**Consultation Response from KC,  
Highways Development Management****2024/92631 10, Thornton Lodge Road, Thornton Lodge, Huddersfield, HD1 3JQ****Installation of replacement shopfront/fascia and external canopy/fascia with integral shutters****Date Responded: 31/10/2024****Responding Officer: CNB****Responding Ref: K6-6NW/4**

Drawing No
 PL10

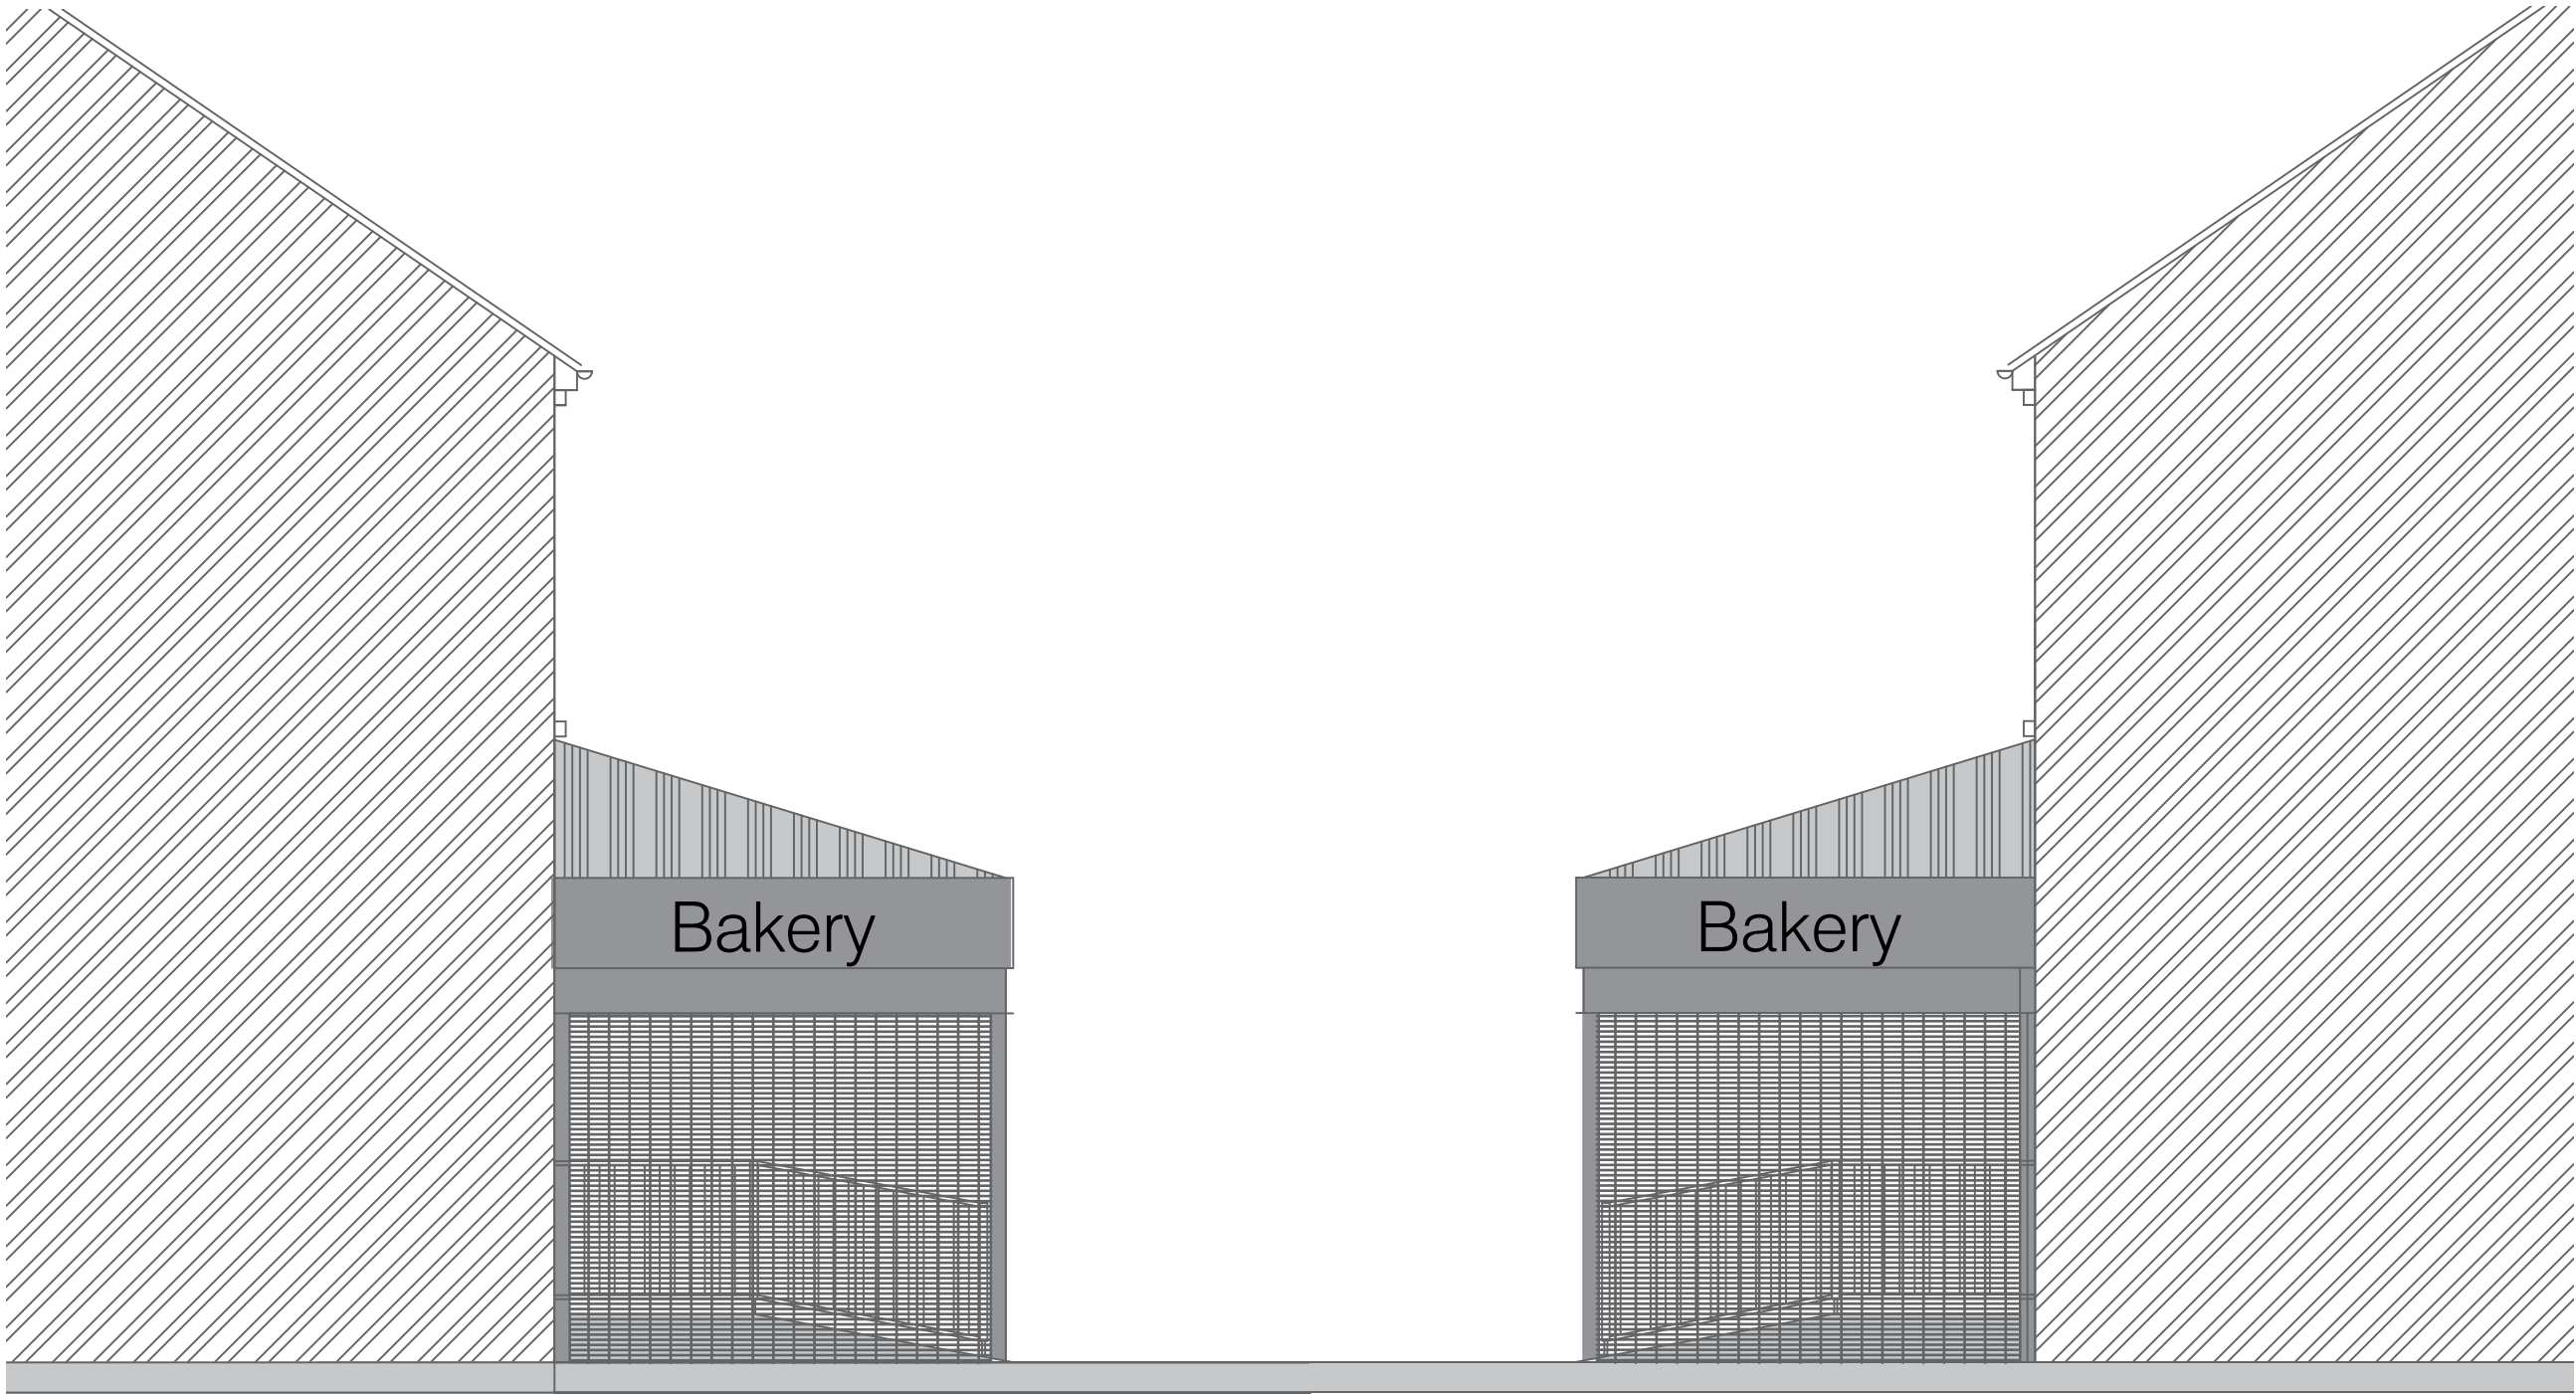
The only concern that we have is with the changes to the proposed pedestrian access ramp in to the shop. Scaled from drawings PL07 and PL10 the ramp has a gradient of approximately 1:6. Current DDA (Disability Discrimination Act) guidance is for ramp gradients of 1:20 with a maximum permitted gradient of 1:12. Section 8.4.2 of Inclusive Mobility guidance document states that "Gradients steeper than 1 in 10 are not only physically difficult to manage but may cause the wheelchair to overbalance." The use of a 1:6 gradient is considered dangerous to users and does not comply with current DDA legislation.

With this we cannot currently support the application due to an accessibility concern relating to pedestrian access to the site.
